**KIRKLEES METROPOLITAN COUNCIL
INVESTMENT & REGENERATION SERVICE**

Reference No: 2020/62/90630/W

Site Address: Old Town Hall, Lewisham Road, Slaithwate,
Huddersfield, HD7 5AL

Description: Erection of detached communal room (within a
Conservation Area)

Drawing number
P 01.

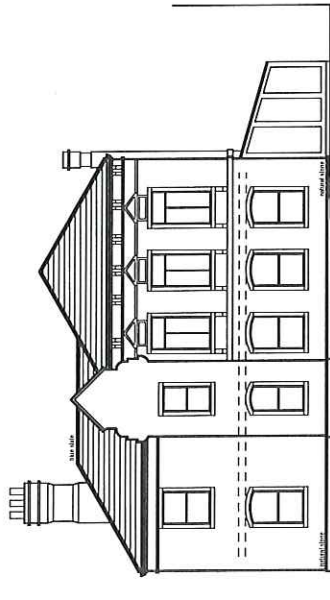
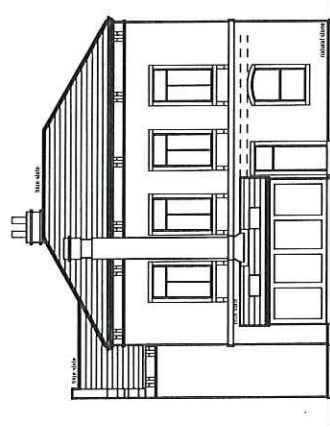
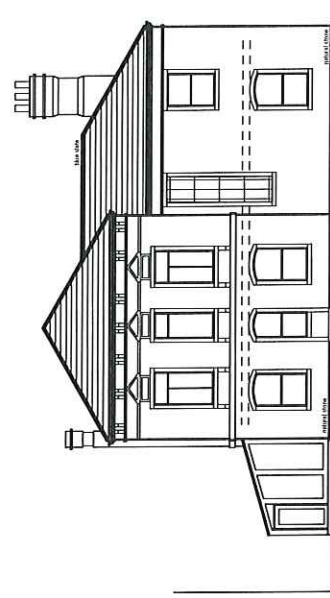
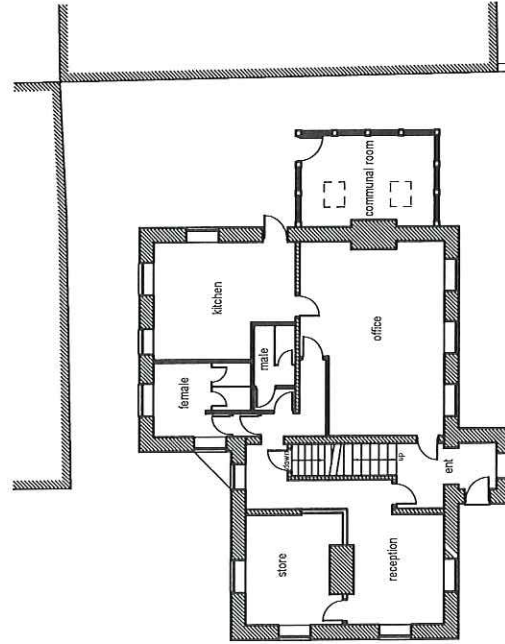
The communal area was proposed as an extension to the east side of the building, and concerns were raised that this would obscure the external chimney stack (an important detail of the building) and that the design of the extension was heavy and plain for such a building. Therefore the applicant's agent was advised to re-site the extension away from the chimney stack and provide an addition which was more traditional in design and lighter in appearance. Following these comments, the applicant's agent provided amended plans on 29th May showing an outbuilding sited away from the building (instead of an extension), which has a lighter appearance, and these addressed officer concerns.

Concerns that the extension would obscure the external chimney stack (an important detail of the building) and that the design of the extension is too heavy and plain for such a building. The extension should be re-sited away from the chimney stack and the addition should be more traditional in design and lighter in appearance.

No objections. The amended plans address the previous concerns.
